From: Ewan Stoddart [REDACTED]
Sent: 30 October 2018 10:56
To: Planning.Responses; Planning
Subject: RE: Further Information Required on Your Ref: PP-07380117 Our Ref: LY/18/18/HH

Further to your email letter of 29th October please find attached the following amended drawings in order to validate our application.

NOTES

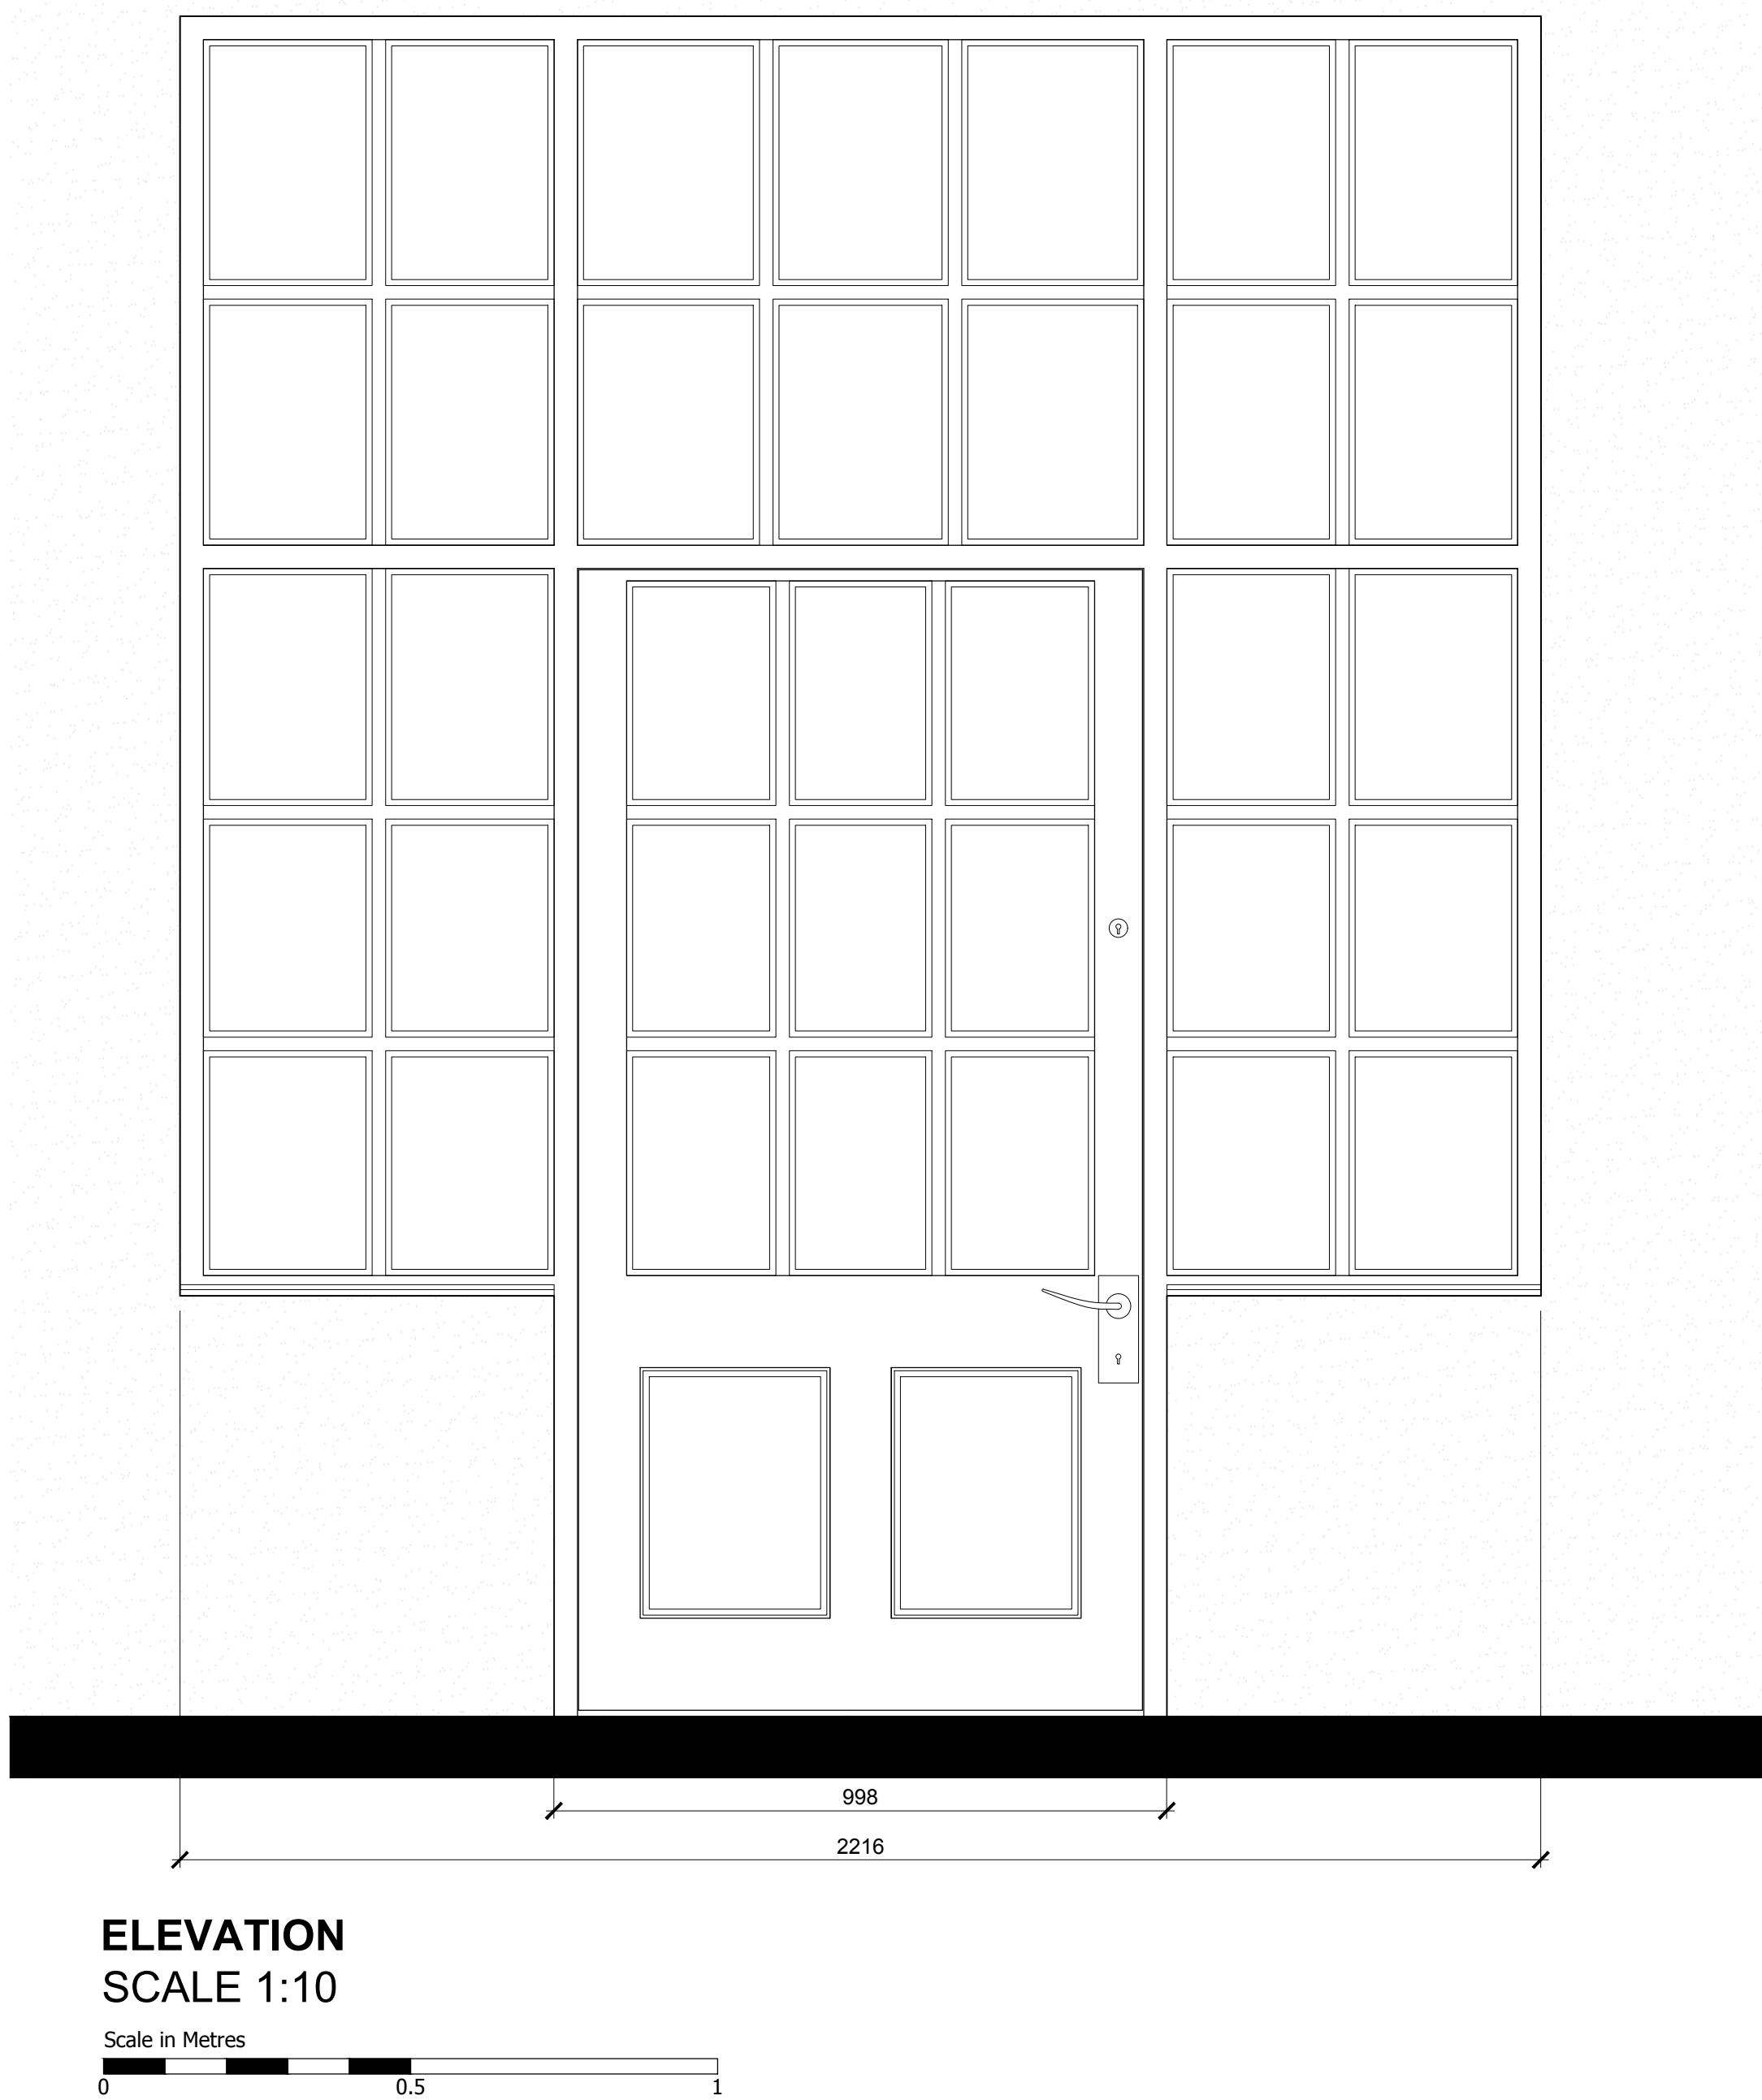
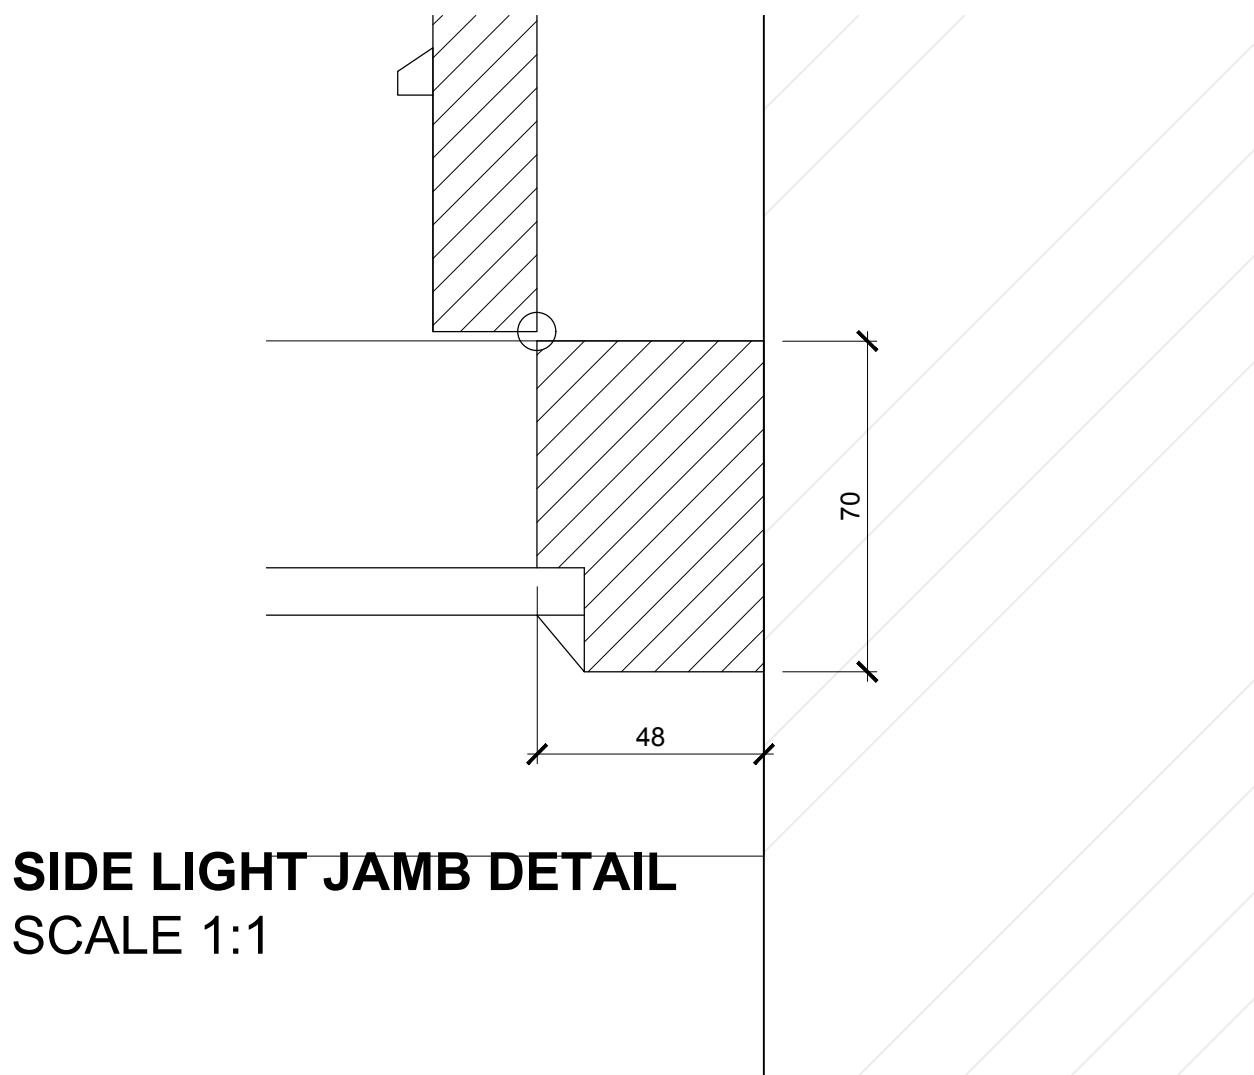
Elevations: The elevations of the door do not measure to the stated scale of 1:100. Please review and amend accordingly.

Savills Response – Please find attached a set of updated existing and proposed door elevations that now correctly states 1:10 Scale (not 1:100 which was in error).
